MIDDLETON STONEY PARISH COUNCIL RESPONSE

to APPLICATION 18/00825/HYBRID : HEYFORD PARK MASTERPLAN

KEY:	
	Shuttle Service to Heyford Station
	Oxford Service
	Bicester Service

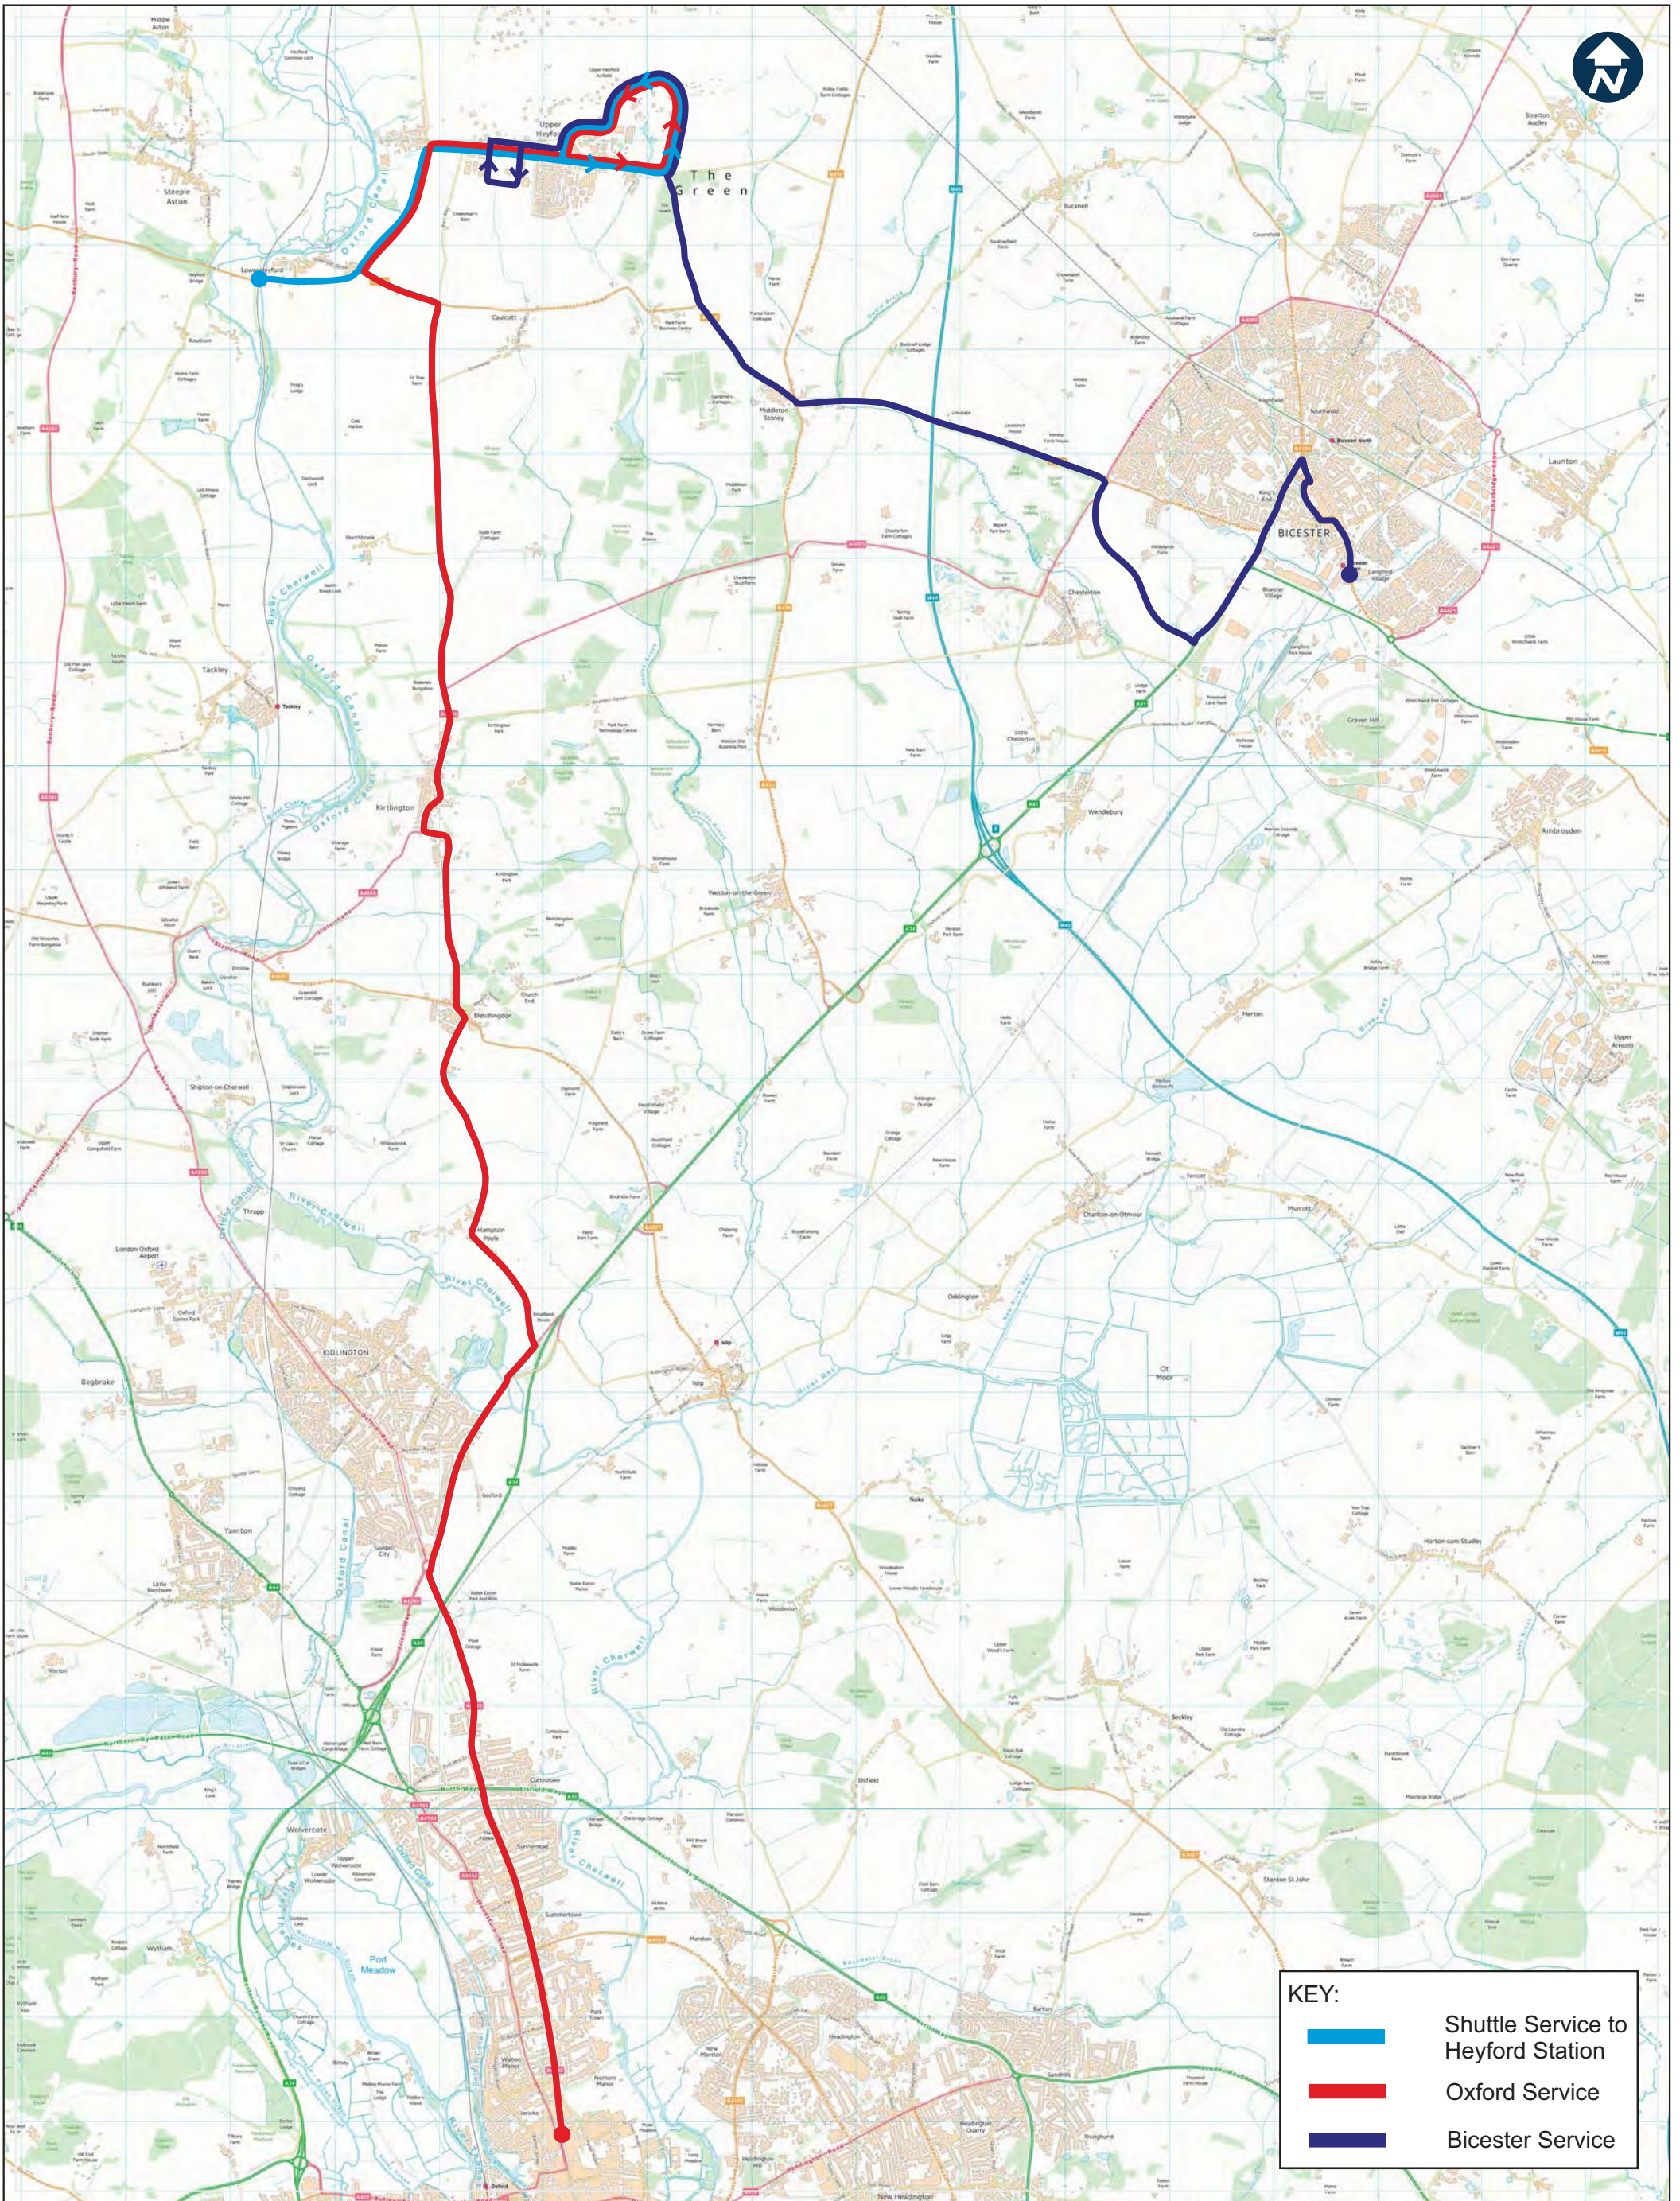
Again we in principle welcome the suggestion of an improved bus service from Heyford to Bicester but are not convinced that it will encourage sufficient passenger numbers from Heyford and subsequently divert traffic from Middleton Stoney. At least initially it will only be twice an hour and it is clear from the extremely low number of passengers (our residents regularly report just 3 or 4 passengers on the 50+ capacity buses) on the existing 250 service that most residents are likely to choose to use their own cars. We have not seen a convincing travel plan from the developers which would convince people to transfer from private cars to public transport, and understand there is at the moment no camera number plate recognition enforcement available in Cherwell to enable the proposed bus gate restrictions to work. Finally there is nothing in the proposed plans about what will happen when the s106 subsidies from OCC run out.

Even if the bus gate enforcement were to work, the likely outcome is simply to divert considerable extra car and HGV traffic down Ardley Road (B430). Many of the cars will then turn left into Bicester Road adding to the long traffic delays at peak times.

Finally we fear the result of this proposed mitigation would be to render the existing 250 service uneconomic depriving Middleton Stoney residents of their existing service to and from Oxford.
